Our Ref: D18/138696

Modification request to amend the approval for the M2 Site (SSD5093MOD4)

I can advise that Council staff have reviewed your proposed amendments at Pier 2 (Bundara Reserve and RMS land). In doing so we acknowledge that Council has no jurisdiction over the RMS/road reservation and that the construction of this pedestrian bridge (already approved) is a vital piece of infrastructure for the North Ryde Station Precinct.

PROJECT	NEW DEVELOPMENT		
DRAWING	TREE LOCATION PLAN - PIER 2		
SCALE	N.T.S. @ A3	ISSUE	REF
DRAWN	LD+AM	CHECK	AM
DATE	22-05-18	REVISION	J

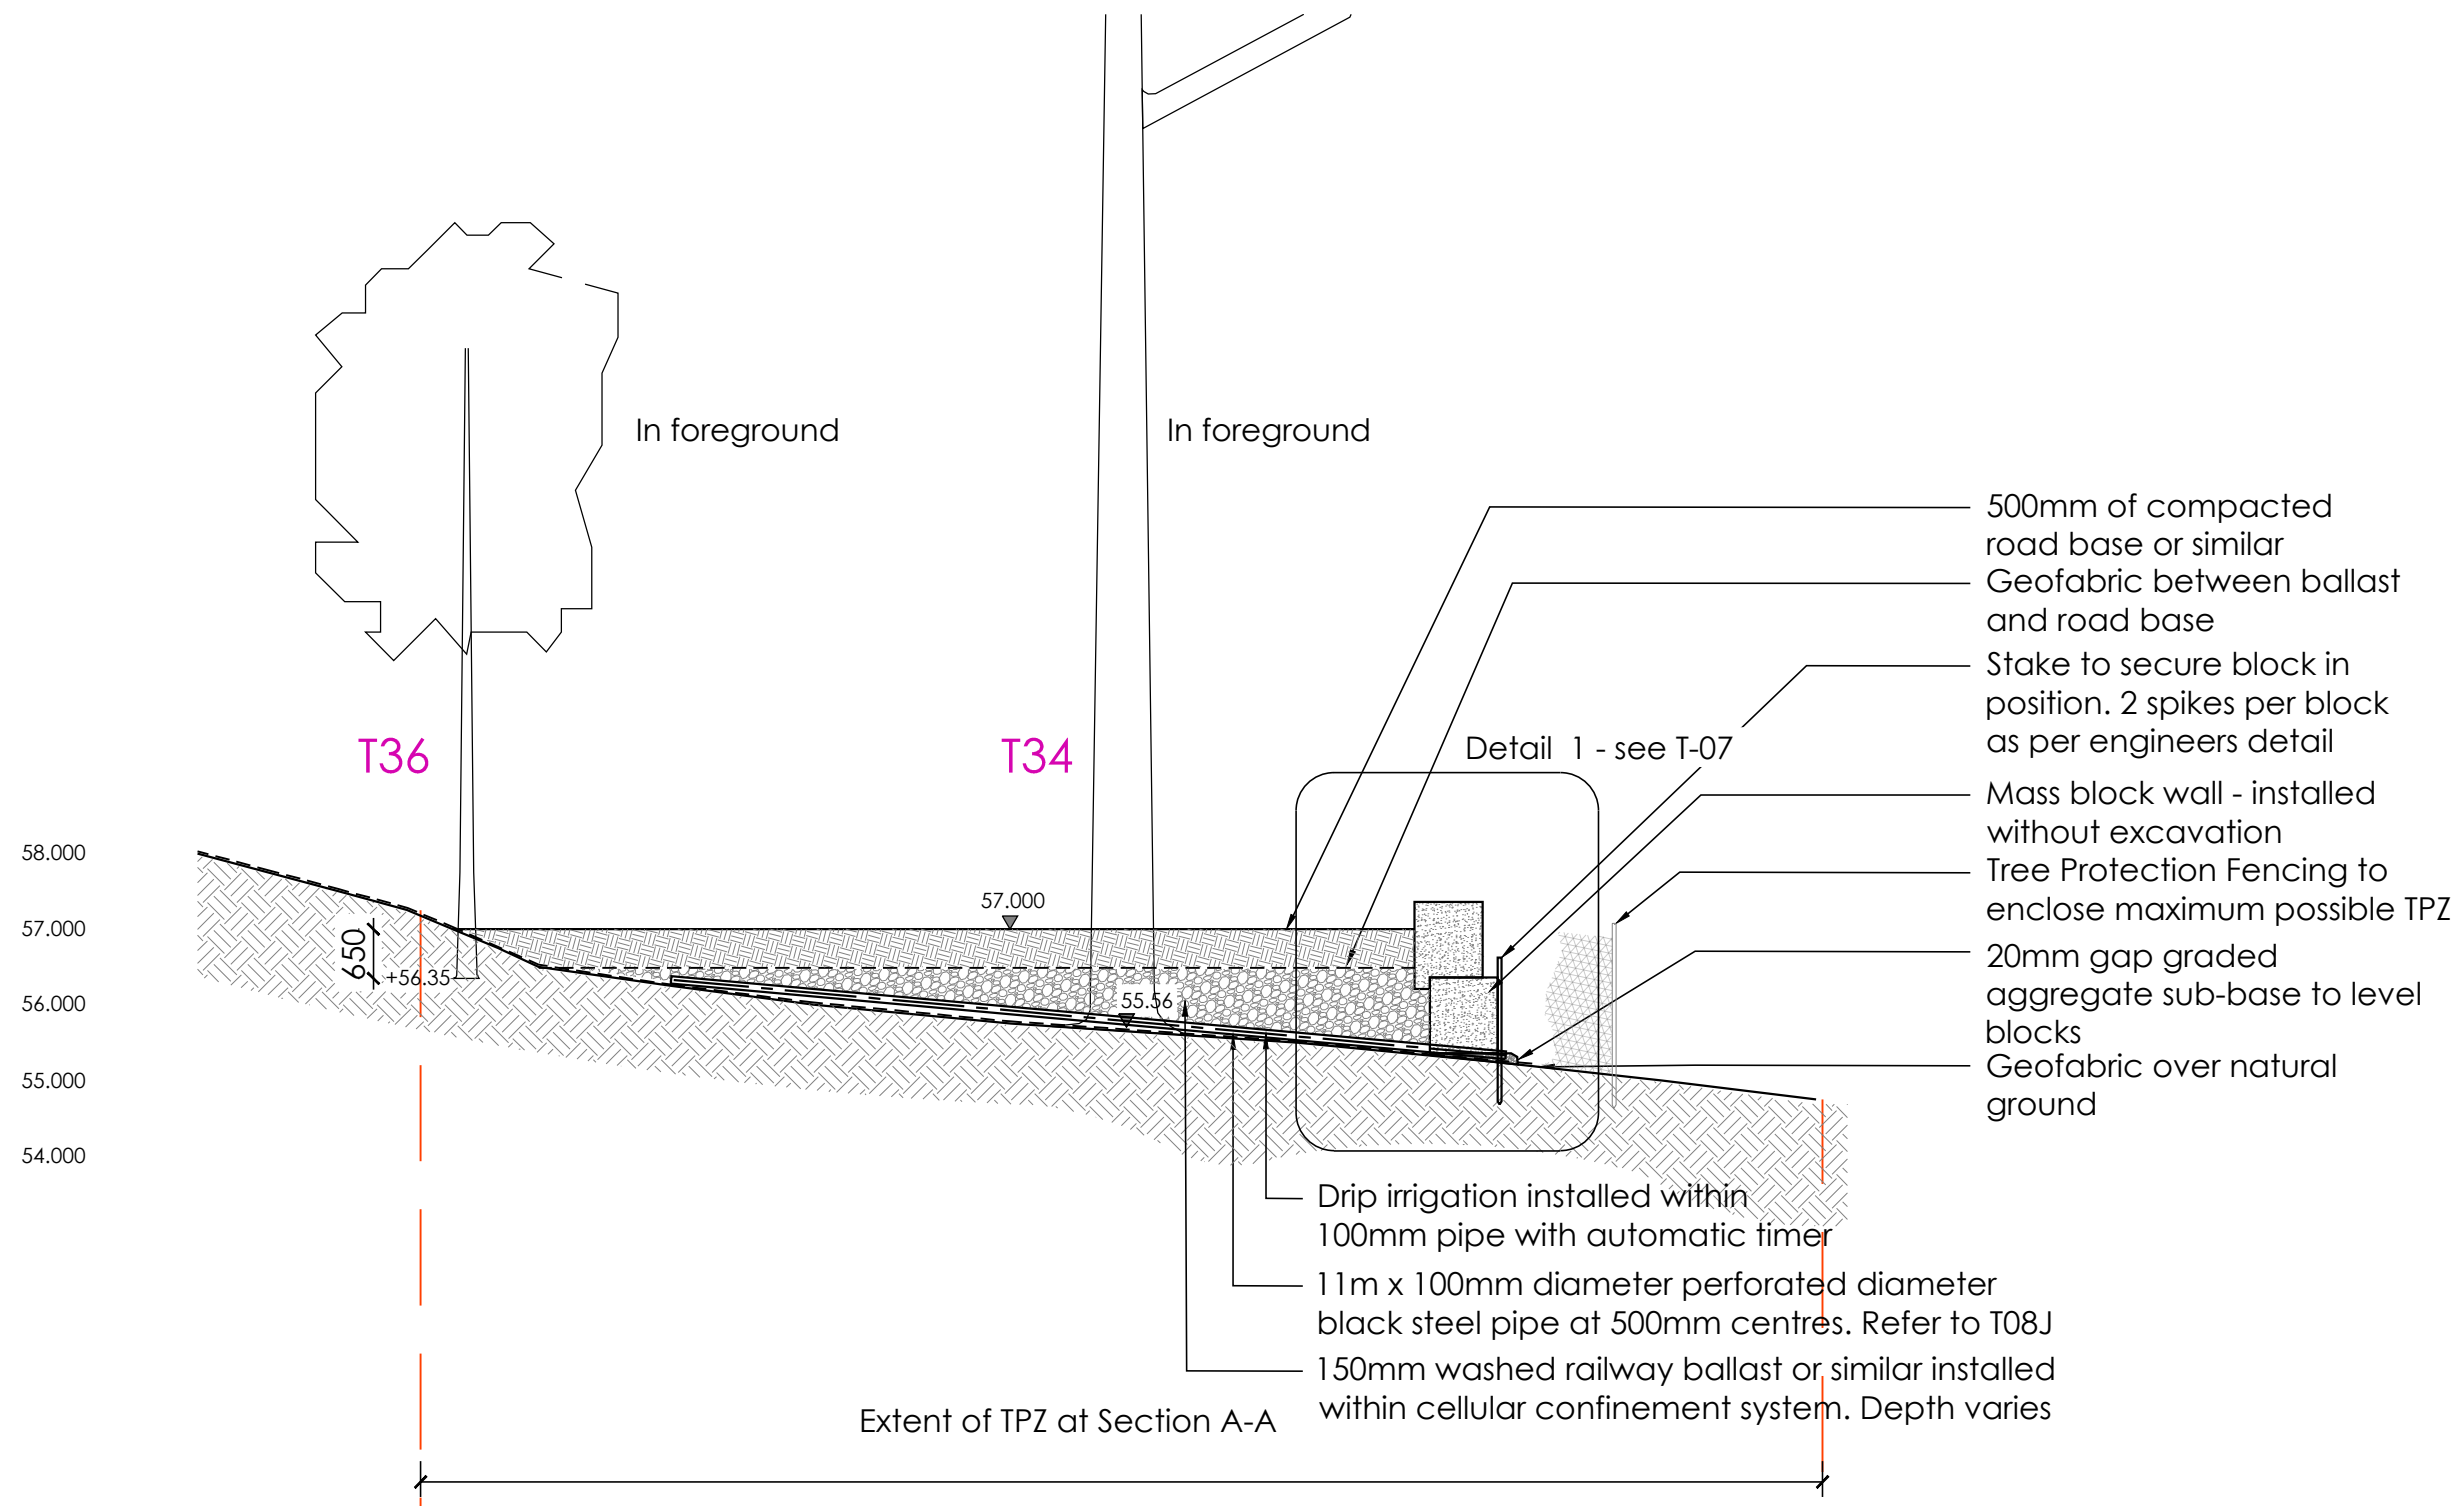
Accordingly, access for construction of the bridge via a temporary 21m² corner section of Bundara Reserve and removal of 3 trees only to allow works for a period of approximately 9 months is supported subject to the following conditions:

- Written confirmation by Landcom that no machinery will enter the reserve at any time other than the nominated 21m² corner section during construction as per the amended plans (May 2018) at any time and that

- this area be clearly defined and securely cordoned off during the construction period.
- All staff inducted into the site are made aware of the sensitivity of the reserve and protective measures are followed whilst works are undertaken

- sediment and erosion controls plans including placement and including locations of any stockpiling of materials
 - Tree Protection plans for the *Eucalyptus Paniculata* Grey Ironbark tree located within Bundara Reserve and the works site be submitted to Council prior to any works commencing for review including mitigation and irrigation considerations
